File No: 2019/123712  
Our Ref: R/2017/28/A  
Your Ref: SSD 8993

**State Significant Development SSD 8993 – SCEGGS Darlinghurst concept approval of the 2040 Masterplan and Stage 1 works**

## **ATTACHMENT A**

**WINTER SOLSTICE
(21 JUNE)**

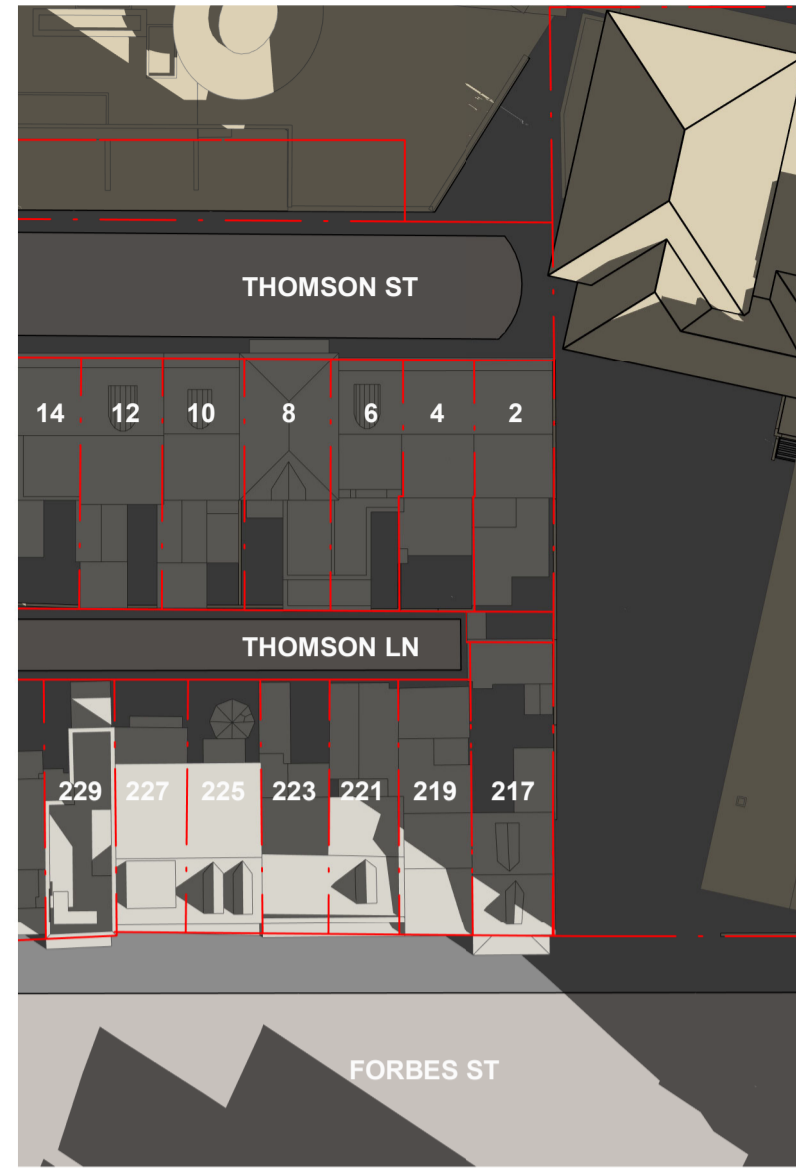
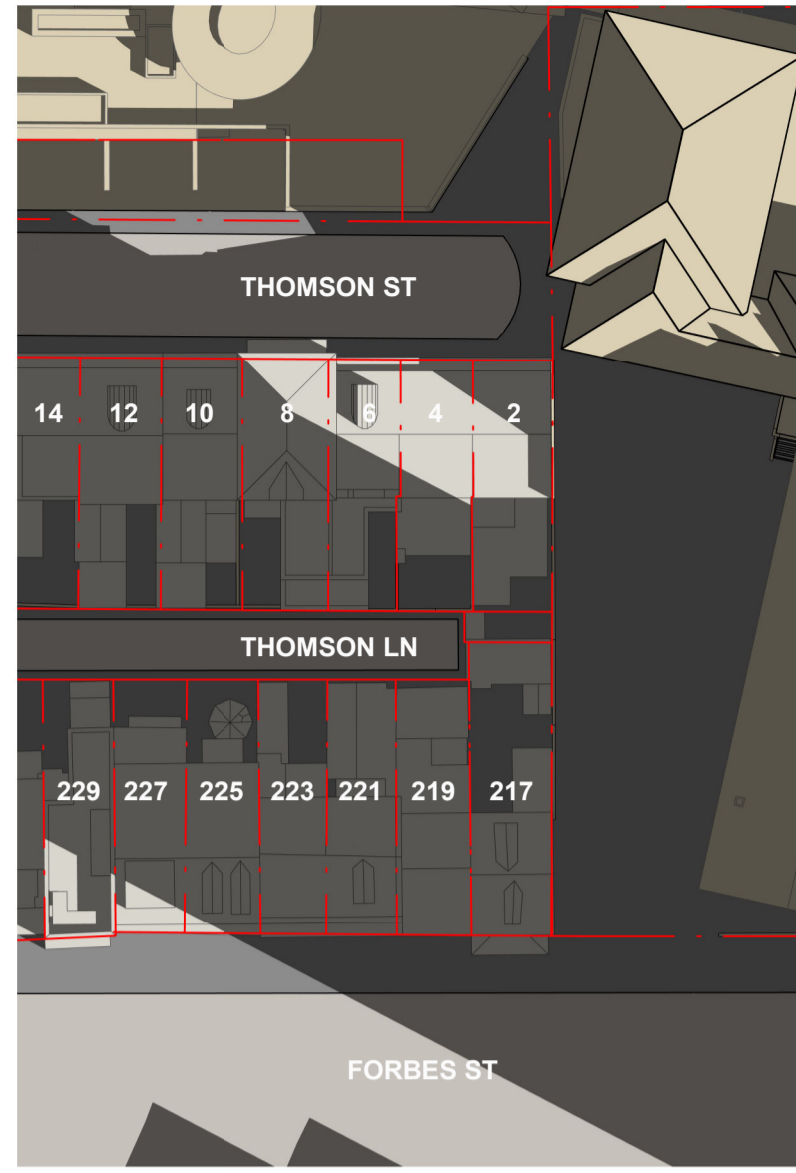
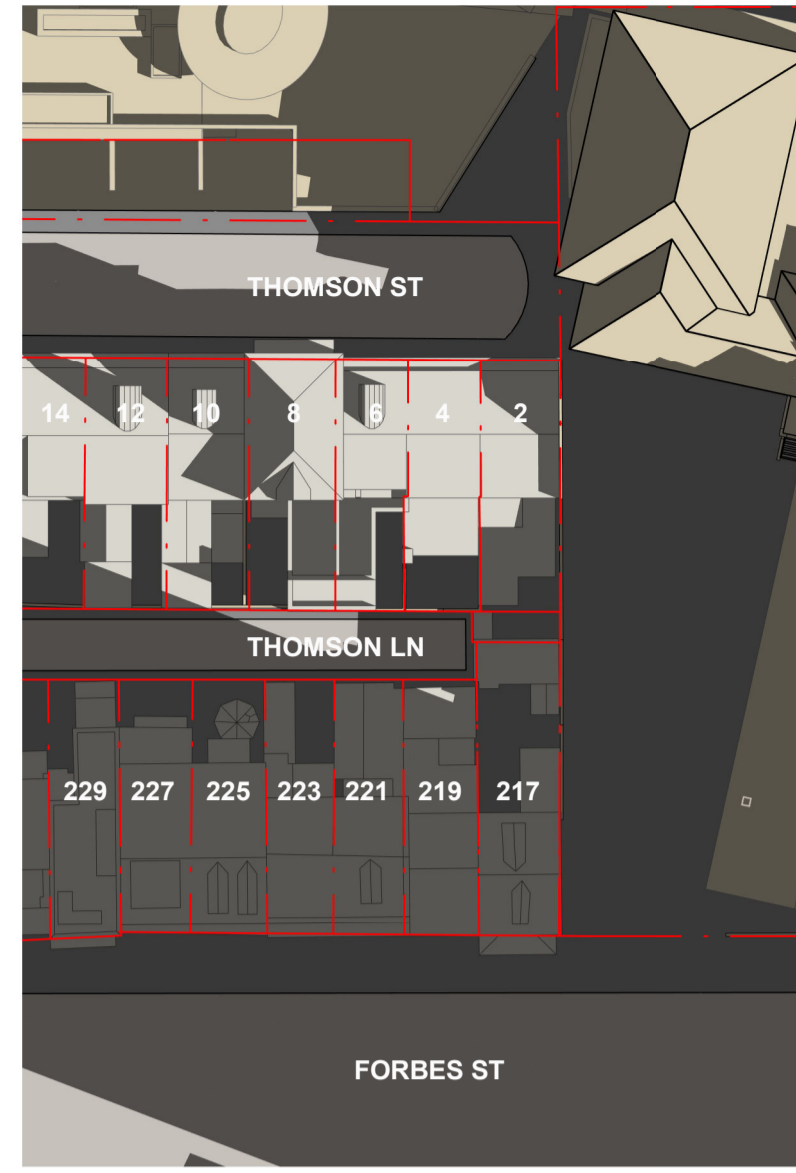
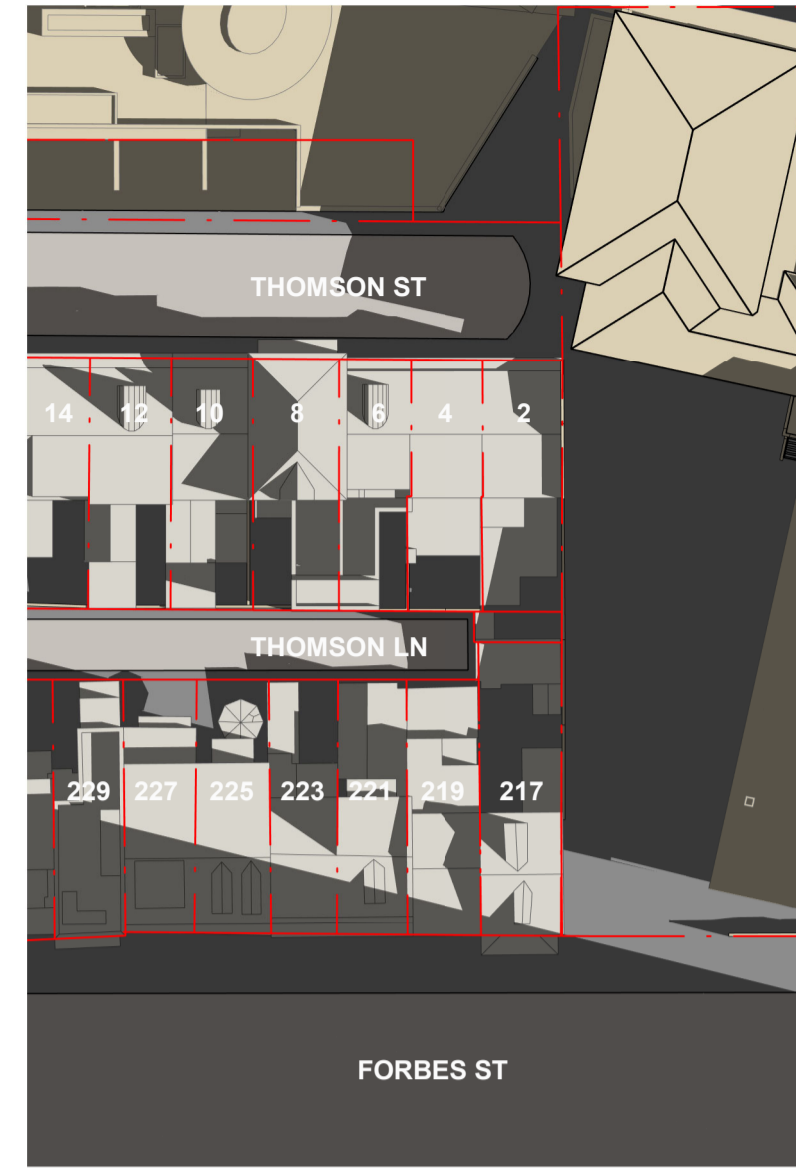
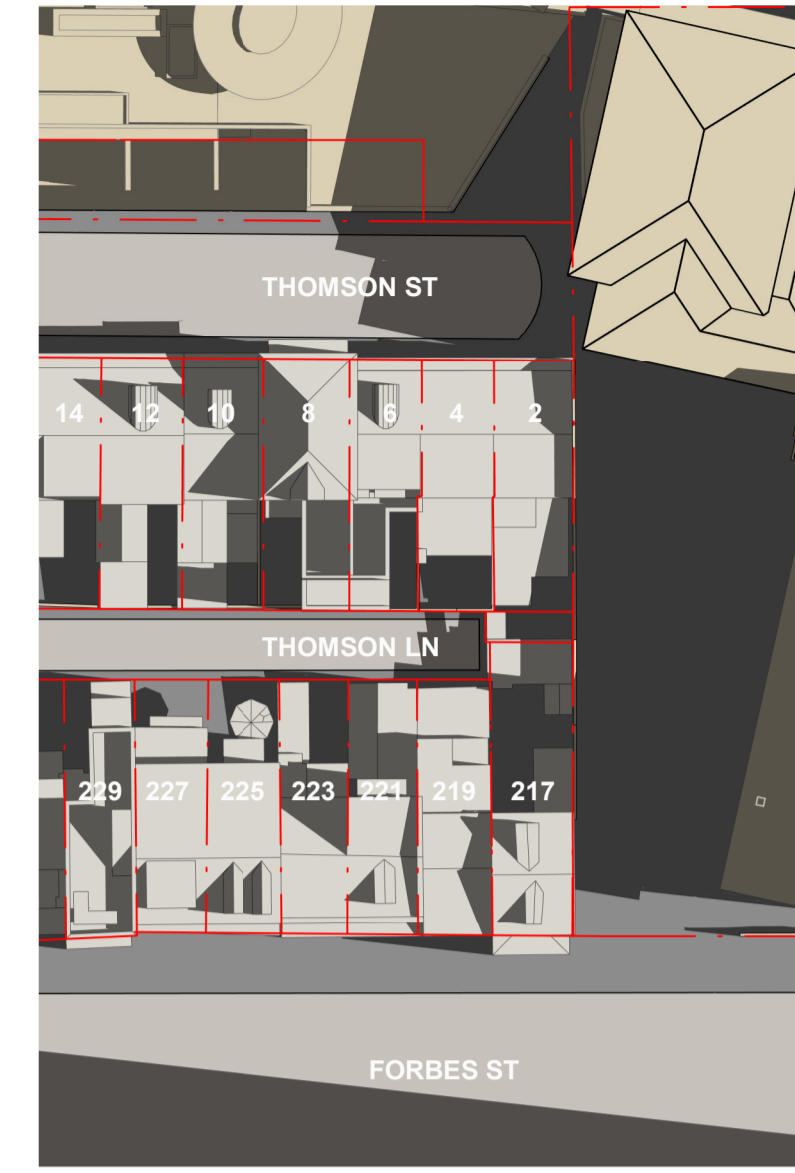
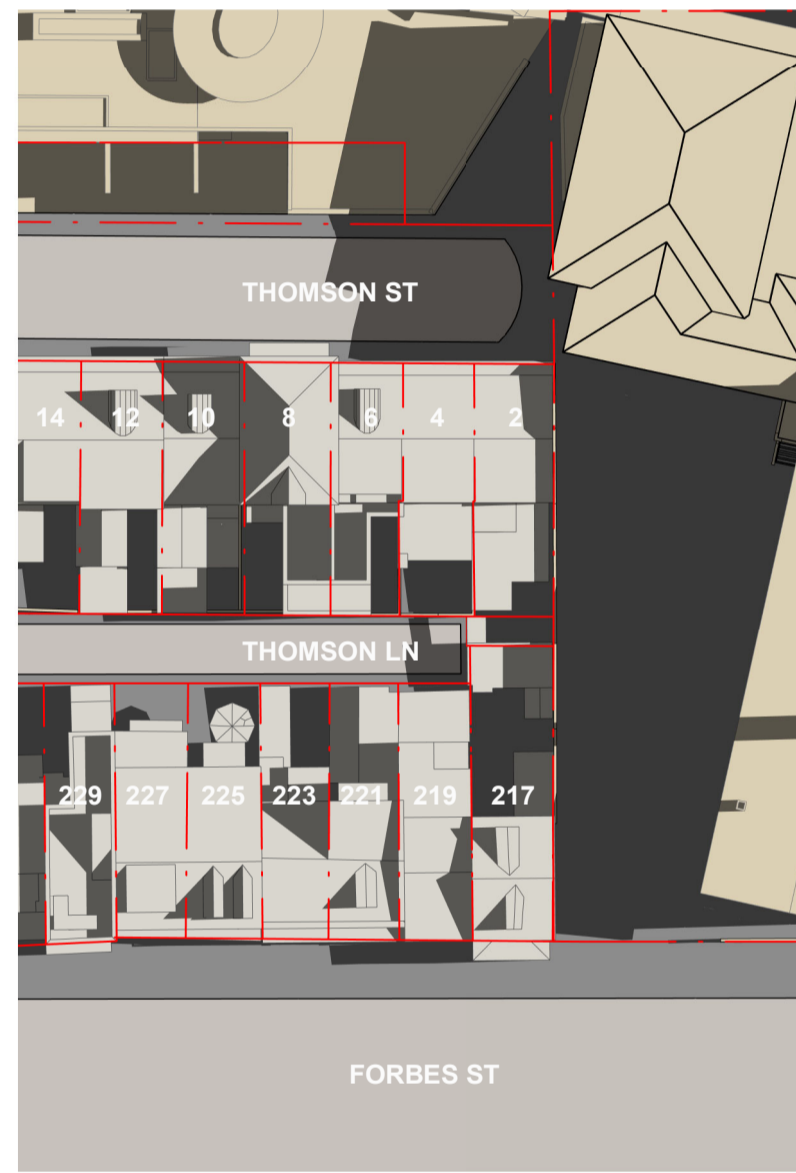
The impact on 4 Thomson Street does not comply with the DCP requirement. The dwelling does not meet the minimum requirements, yet is being made worse by the development.

Shadow diagrams in elevation demonstrate that 6 Thomson Street currently receives sun in their front downstairs room from 1pm-3pm. This will be lost due to the proposed development. It is likely this is the window to the main living /dining area within the dwelling.

These impacts are not acceptable.
